REQUEST

Current Zoning: R-4 (single family residential)
Proposed Zoning: R-12MF(CD) (multi-family residential, conditional)

Approximately 4.2 acres located on the south side of Lakeview Road, west of Reames Road, and east of Beatties Ford Road.

The petition proposes a residential community of up to 41 single family attached dwelling units on vacant land.

RZ.01

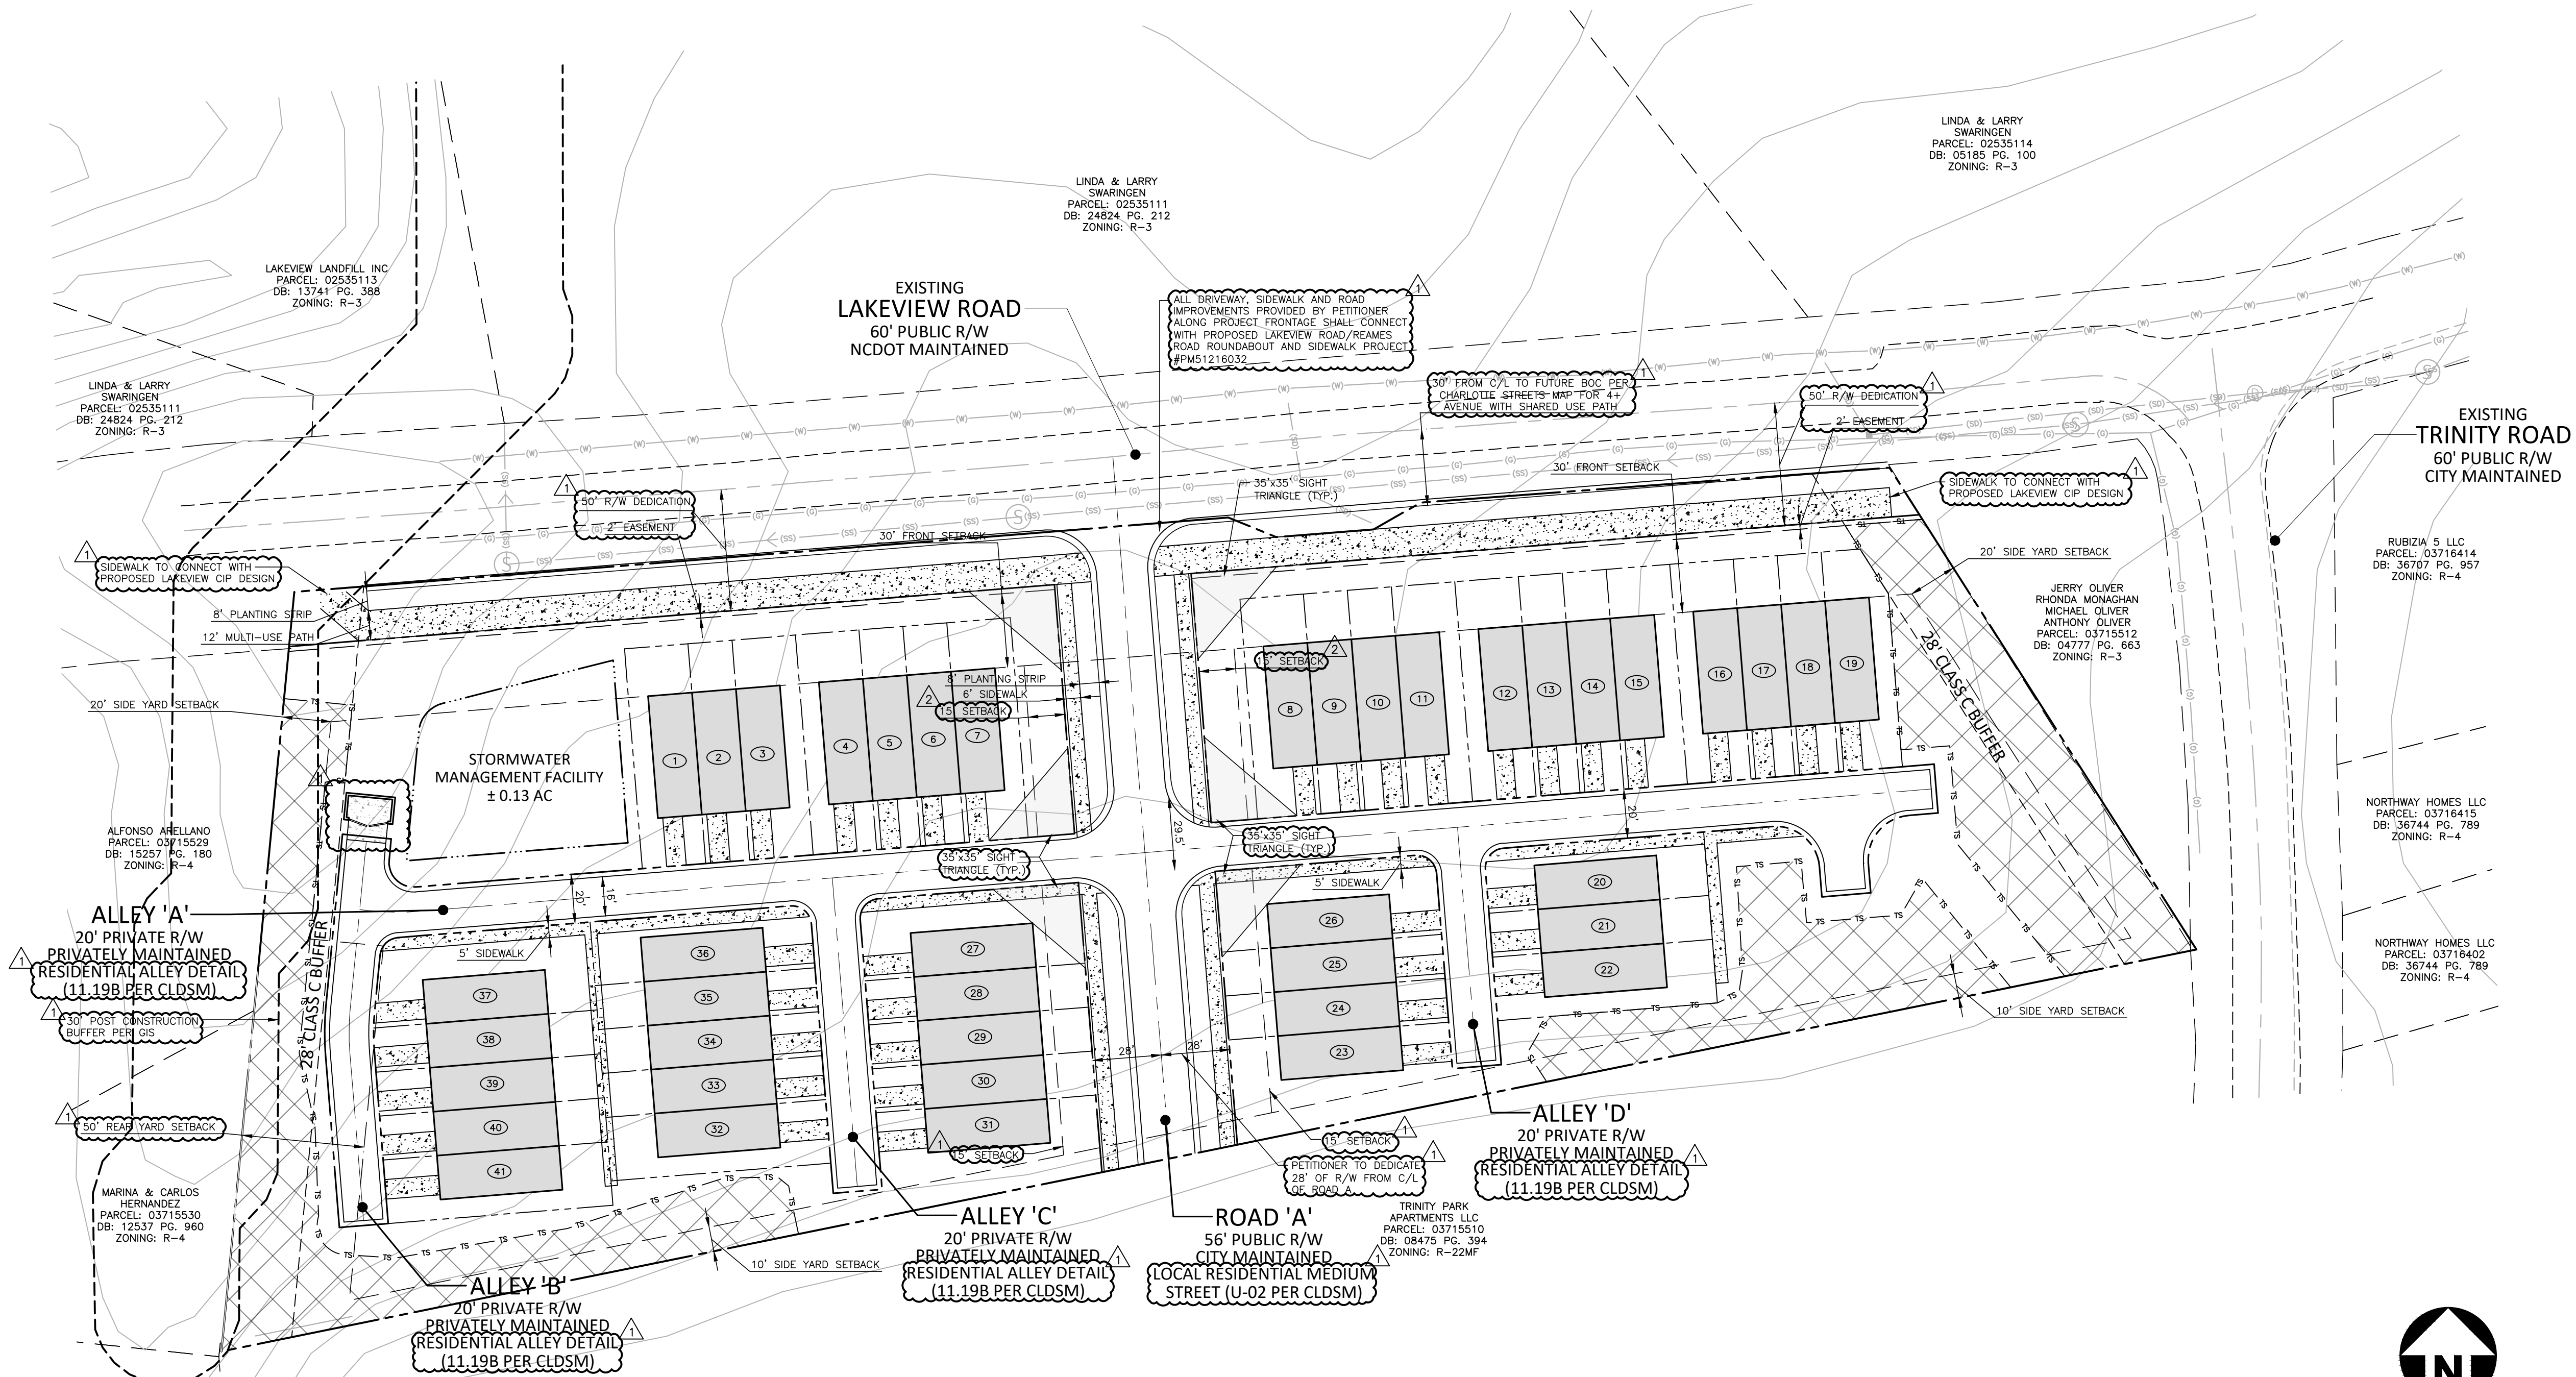
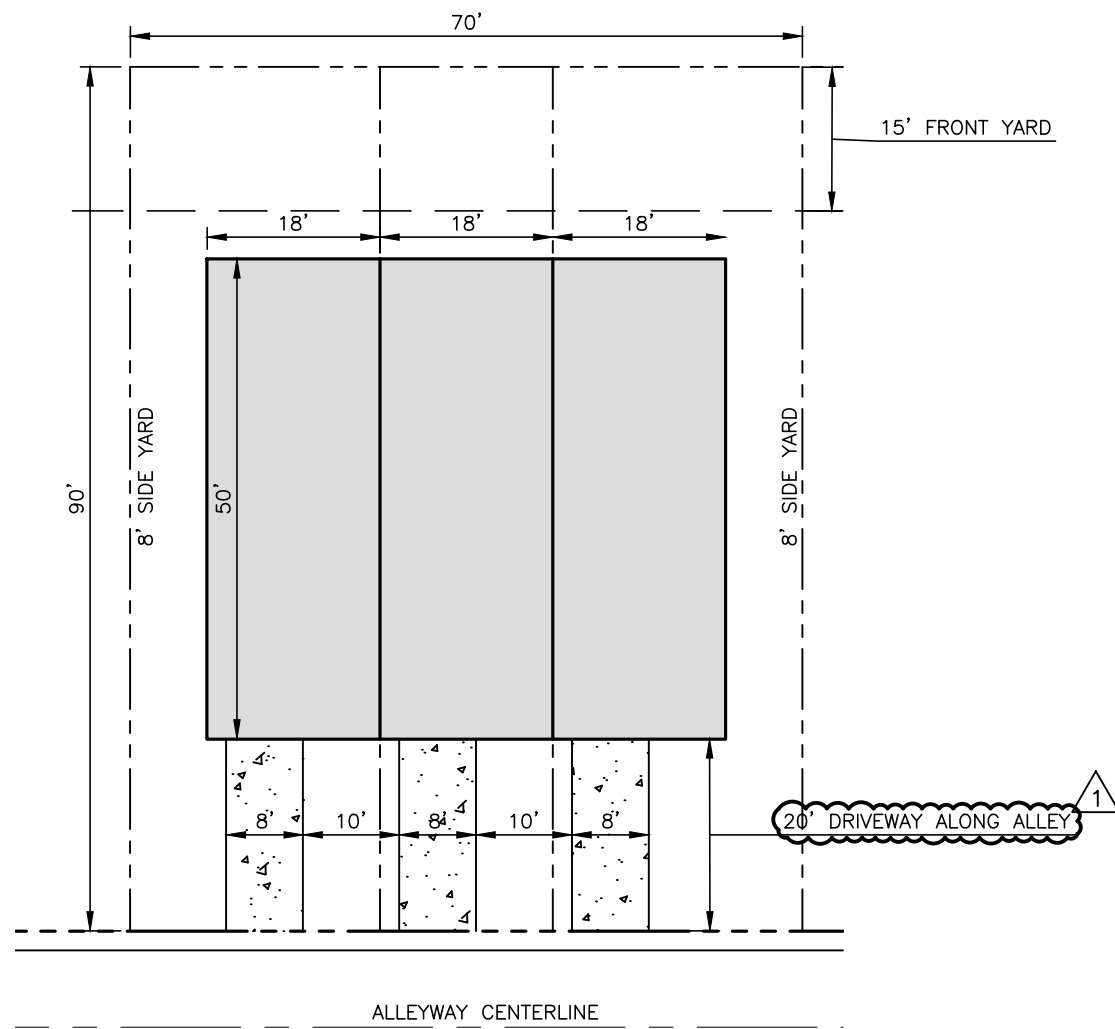
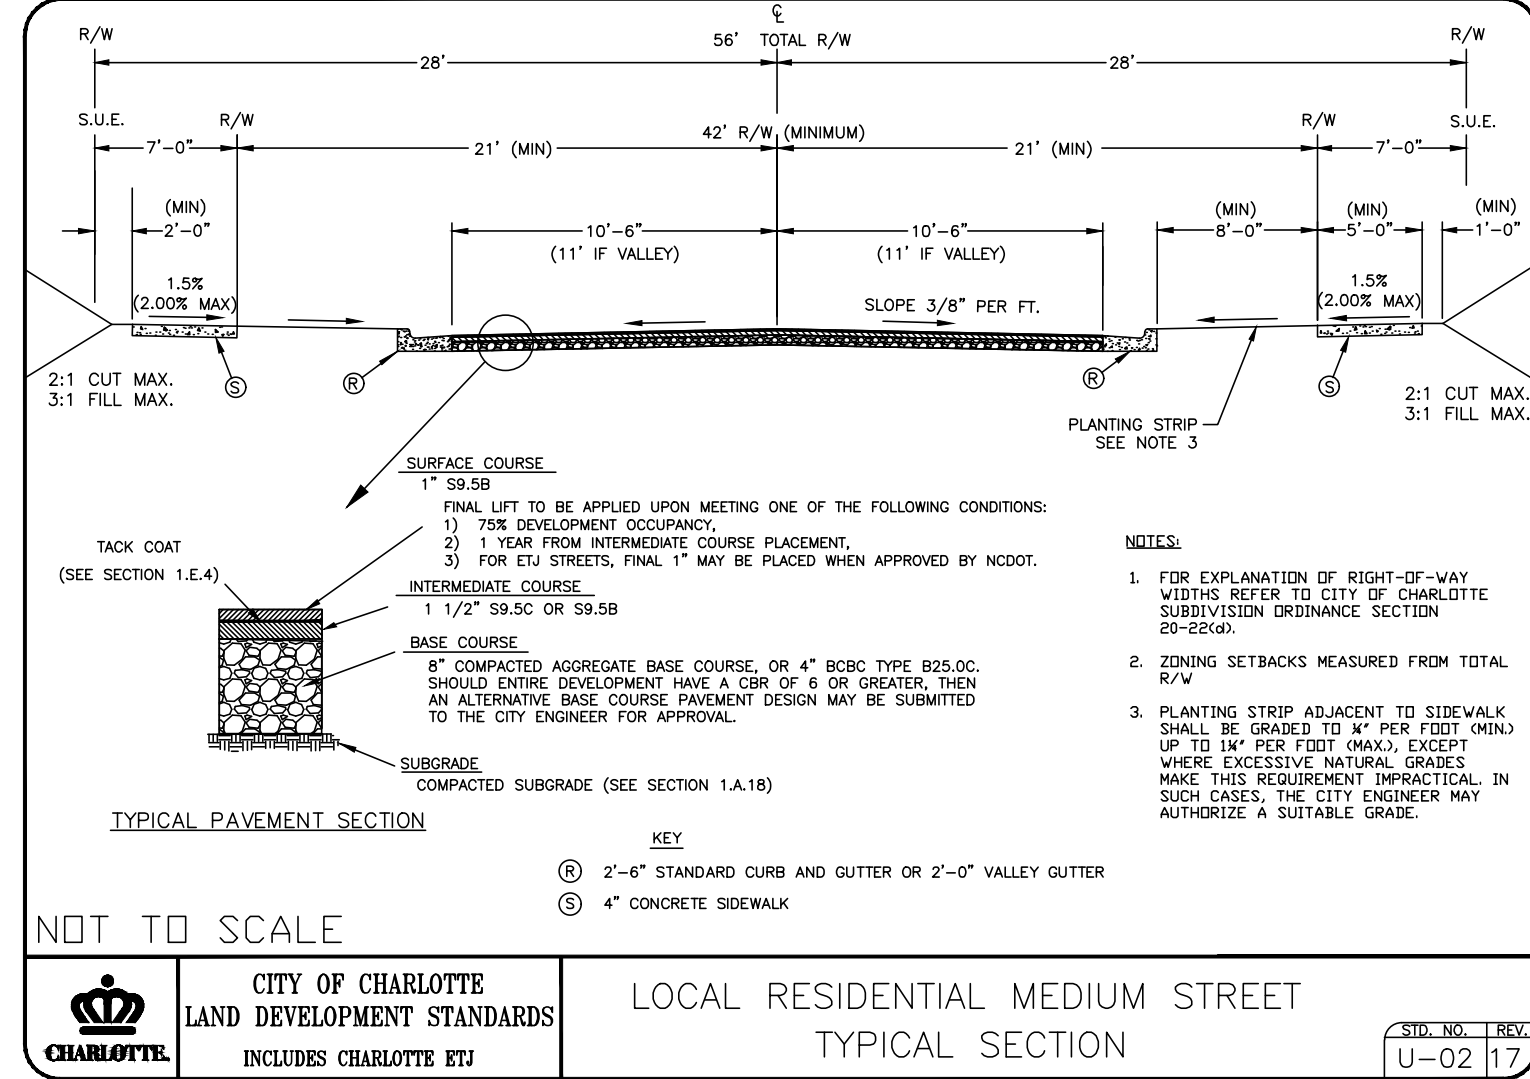
- ~~1. Add a conditional note specifying "A Right of Way Encroachment Agreement is required for the installation of any non-standard item(s) (irrigation systems, decorative concrete pavement, brick pavers, etc.) within a proposed/existing City-maintained street right-of-way by a private individual, group, business, or homeowner's/business association. An encroachment agreement must be approved by CDOT prior to construction/installation. Contact CDOT for additional information concerning cost, submittal, and liability insurance coverage requirements."~~ Addressed
2. Driveways will be required to be moved out of sight triangles. Addressed
